PLAN-010213

Proposal: Variation of condition 3 imposed under planning reference LU/203/13/ to enable the reorientation of plots 5 & 6.

Site: Willowbank Cottages, The Poplars, Littlehampton, BN17 6GZ.

LU/106/15/PL

SITE LAYOUT PLAN

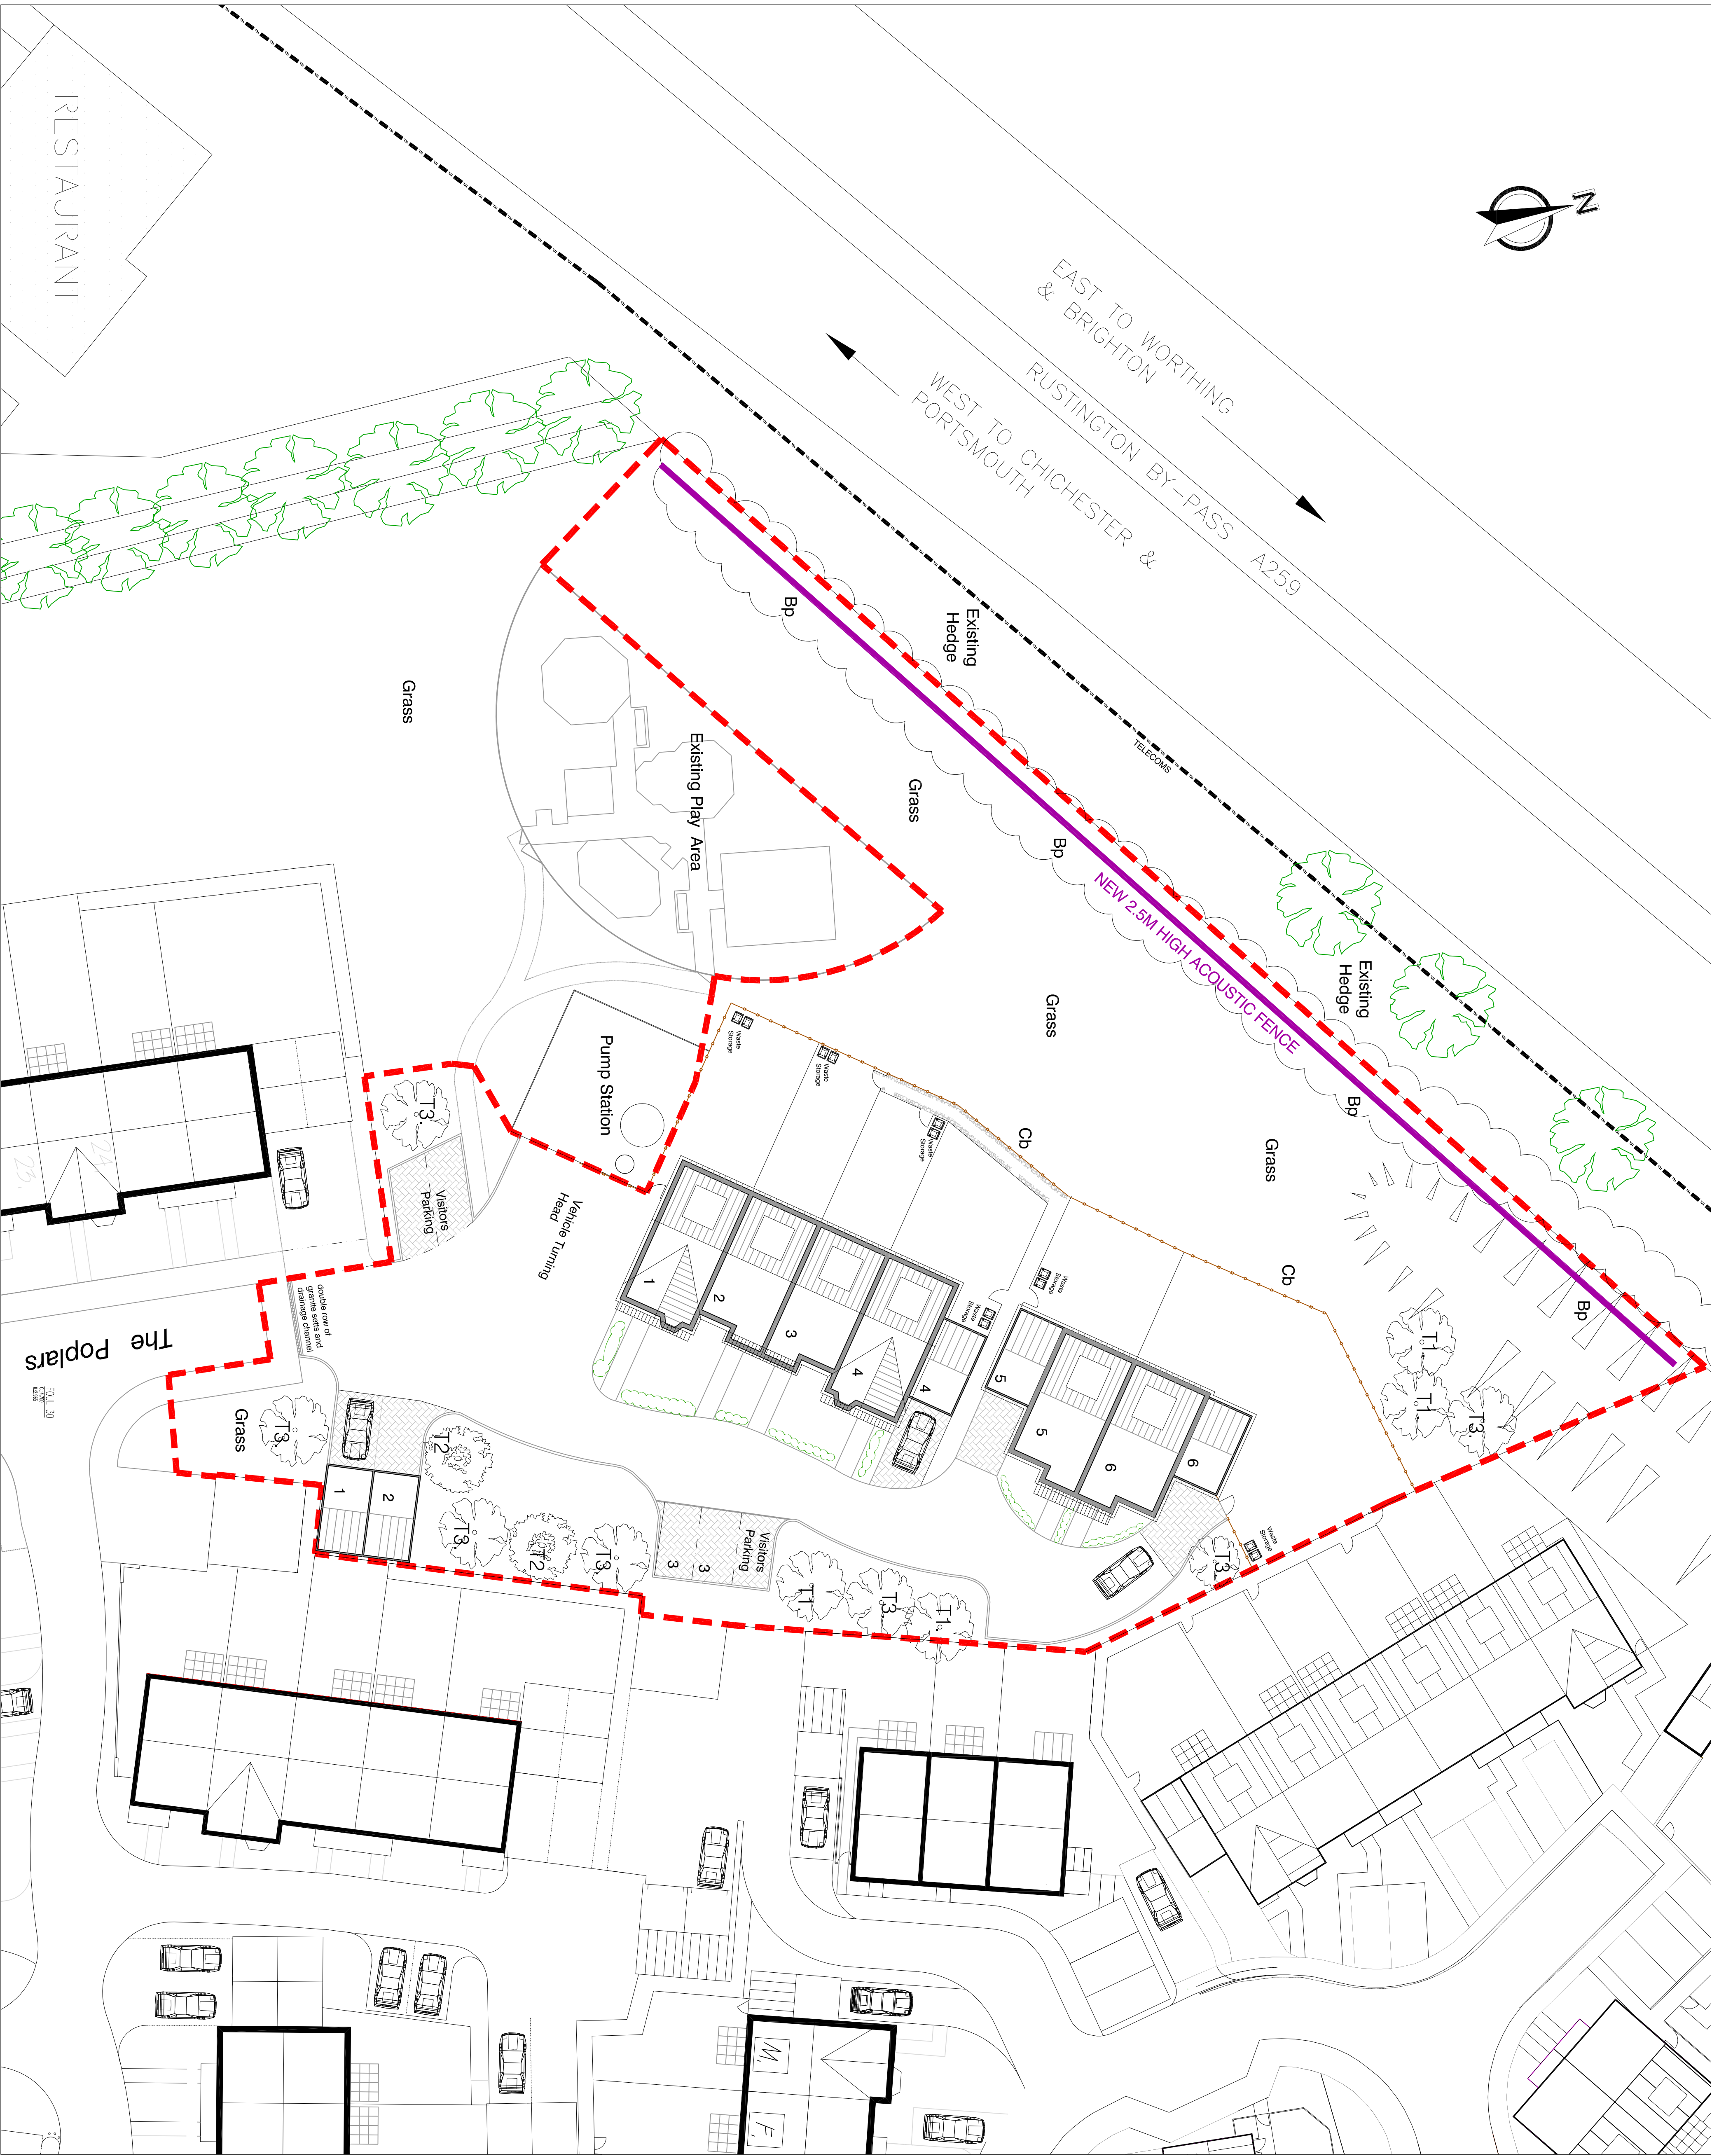
The submitted layout shows residential plots being close to the pumping station which is not acceptable to Southern Water.

Due to the vibration, noise and potential odour generated by sewage pumping stations, no habitable rooms should be located closer than 15 metres to the boundary of a proposed pumping station site.
